CITY OF ALBUQUERQUE

September 14, 2017

RE: Commercial Addition, **Lot 5-A, 11-A, 13-A, & 15-A, Block 2**
Grading and Drainage Plan
Engineer's Stamp Date 9/05/2017 (J14D186)

Lots 5-A, 11-A, 13-A and 15-A, Block 2 Commercial Addition GRADING PLAN			
DRAWING: 201622-GD.DWG	DRAWN BY: SH-B	DATE: 3/25/2017	SHEET # 1

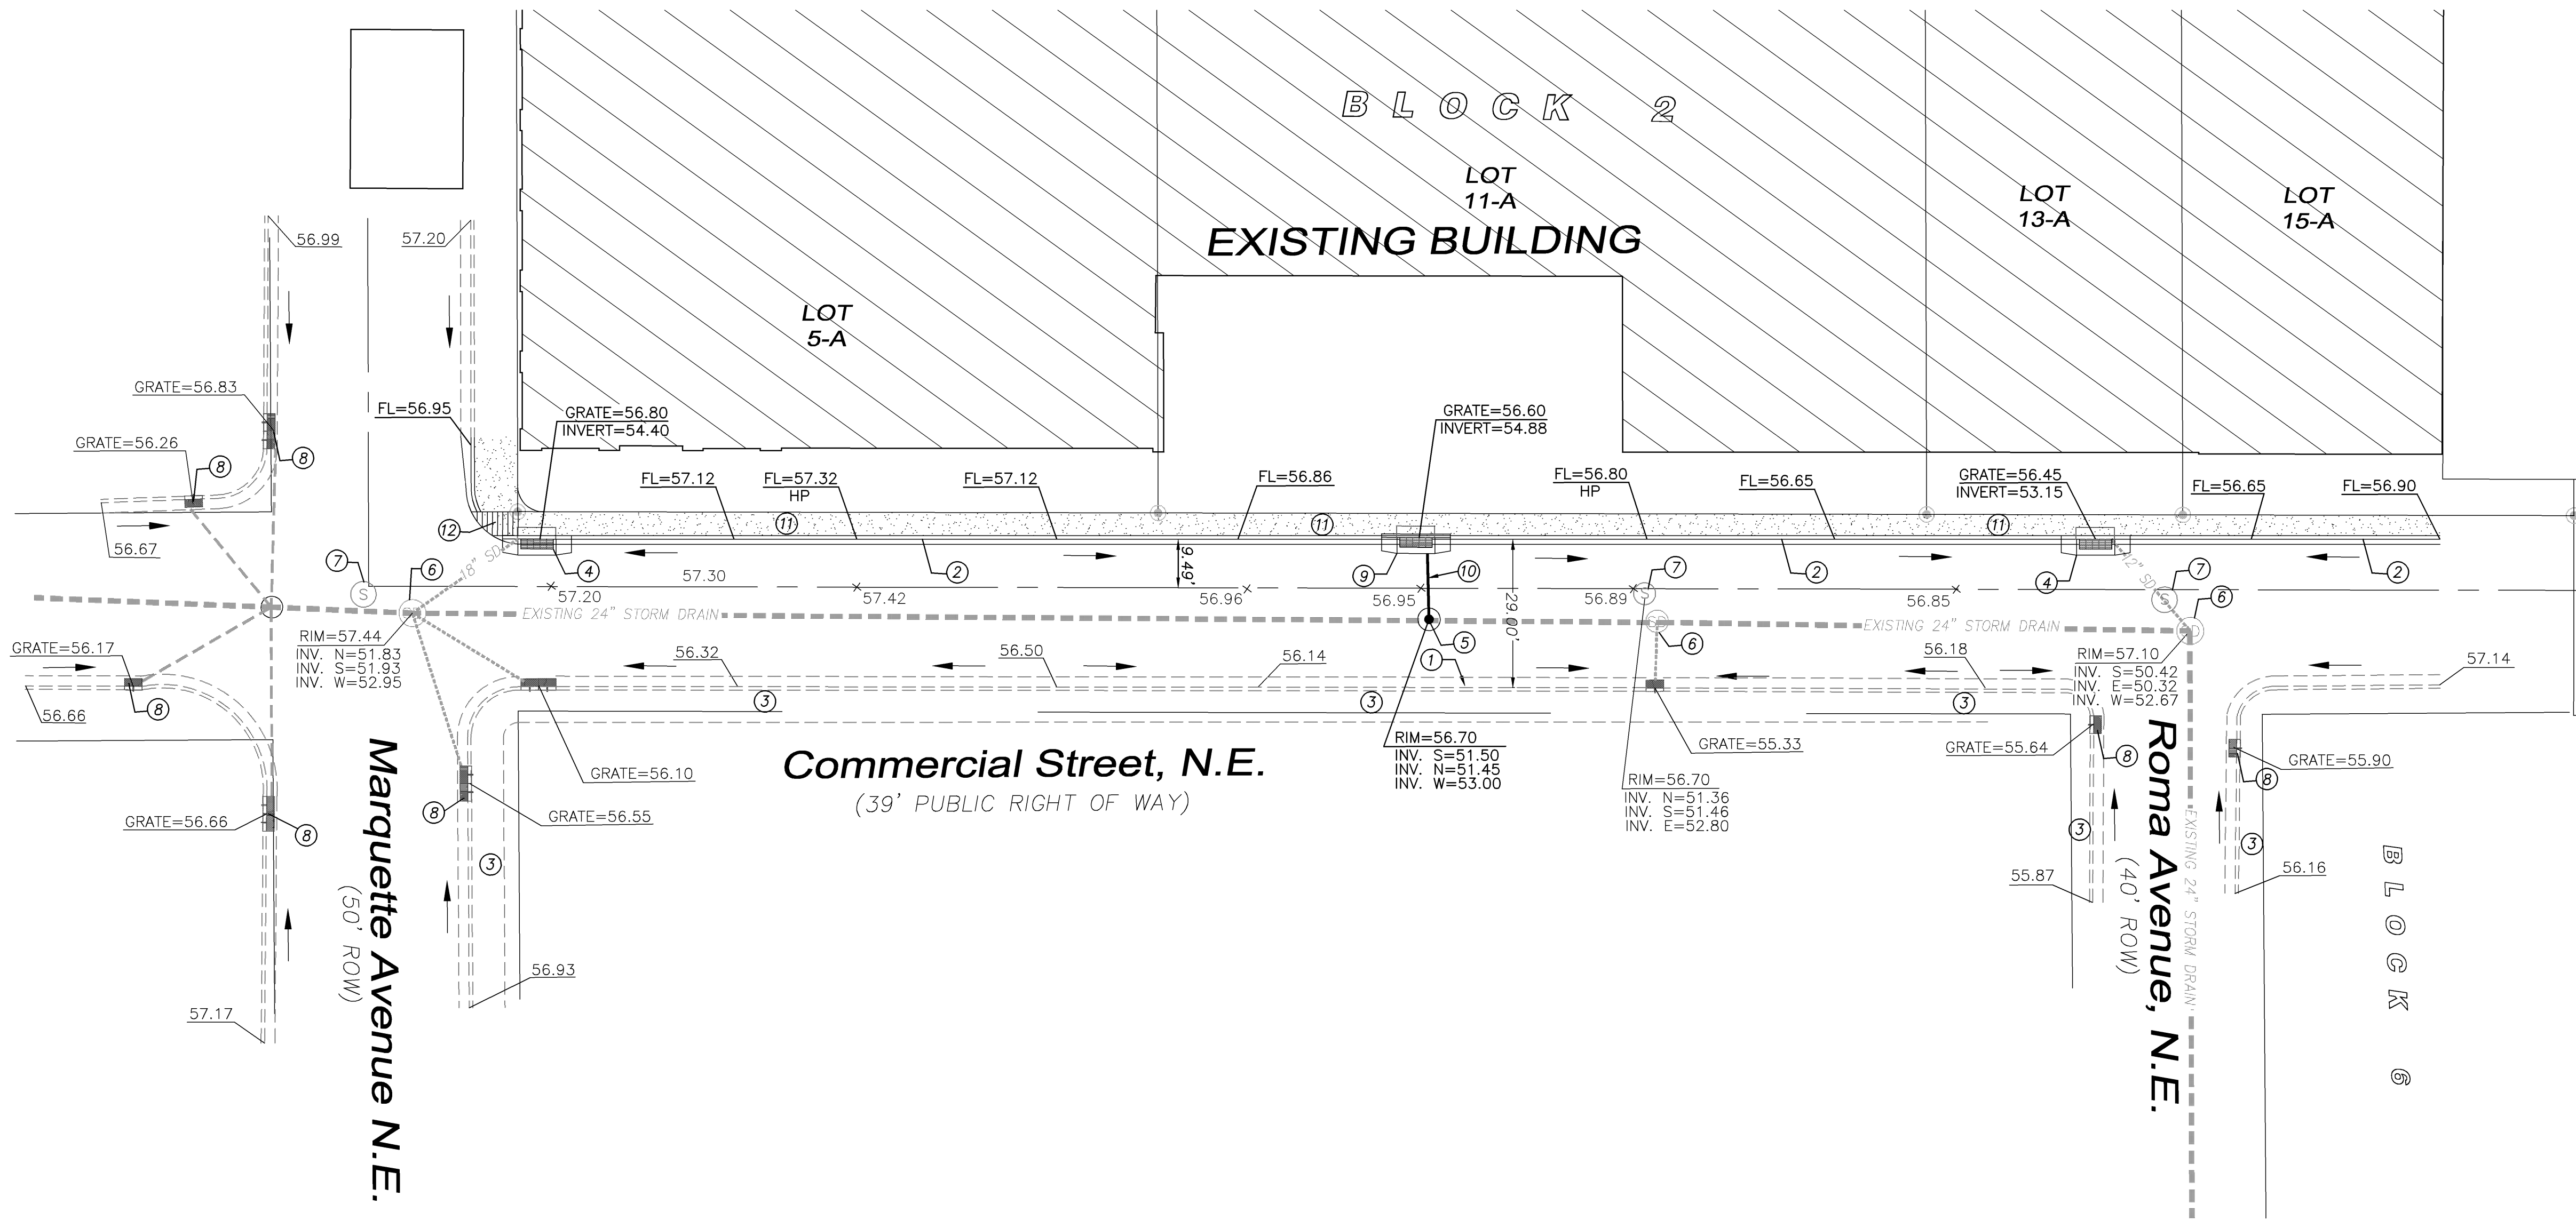
- The spot elevations of the new curb do not agree with the ALTA elevations. Show both the existing curb elevations and the new curb elevations adding more elevations from the ALTA.
- It further appears that the existing road has an inverted crown. A combination of new inlets and repaving of the street should be designed to eliminate any bird baths in the street.
- The south inlet should be a double C since that is what exists there now, and the other two inlets should be according to the approved infrastructure list.
